**Queensland-Hunter Gas Pipeline, Wallumbilla (QLD) to Newcastle (NSW)
(Major Project Reference: MP 06_0286) – Review of Draft Environmental
Assessment**

This section is the response from the DPI (Coal Advice) and is additional to the earlier response (ref: 08/7514).

Figure F13 Biodiversity and Management constraints - Muswellbrook area

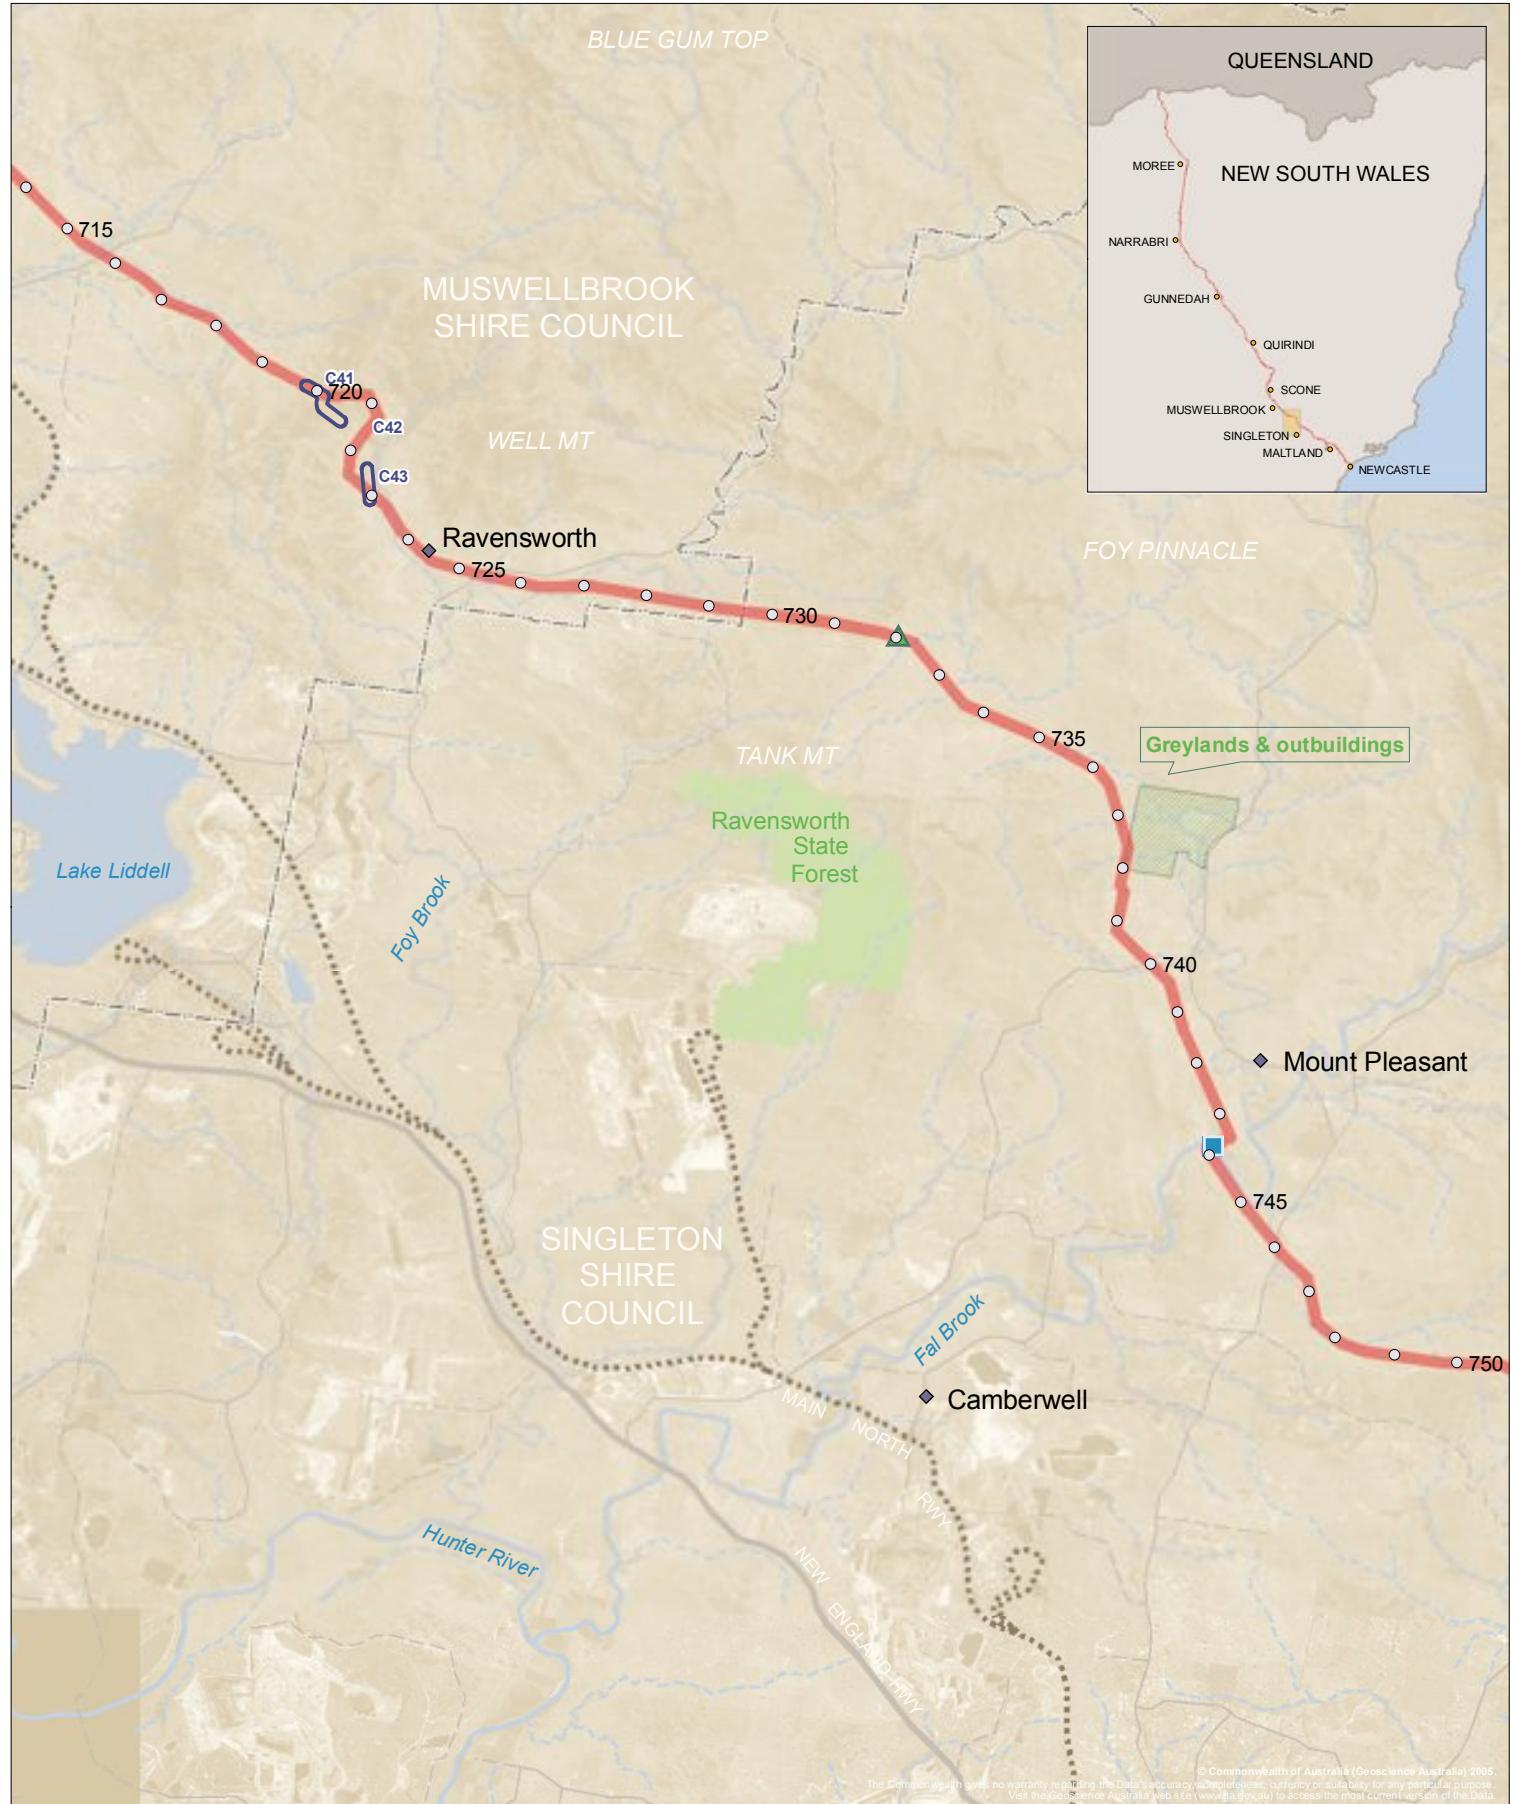
The route west of Scone is over coal bearing strata. Analysis of the coal resources in this area revealed a conflict in the area south west of Scone between KP680 and KP690 (Fig. 1). DPI (Coal Advice) requires that the pipeline route be altered to closely follow the New England Highway/Railway line between Scone and Aberdeen (Fig. 2).
